Subject: RE: EP/25/20/CLP - Confirmation of materials

This email is regarding the above application at The Millstone, Sea Lane Close, East Preston.

1437/P02

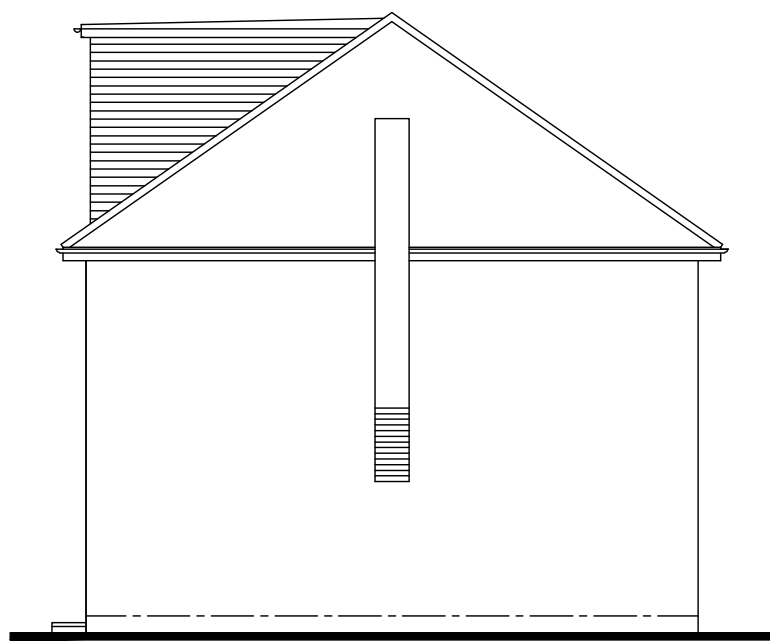
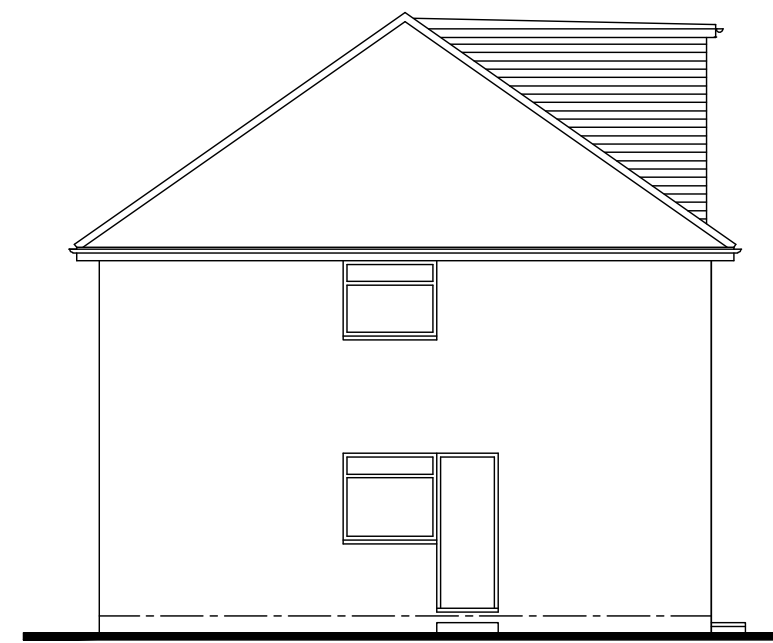
Sorry to chase, but are you able to clarify the colour of the tiles used?

The 'Walls' has been detailed as 'Tile Hanging Colour T.B.C', are you able to confirm the material that will be used?
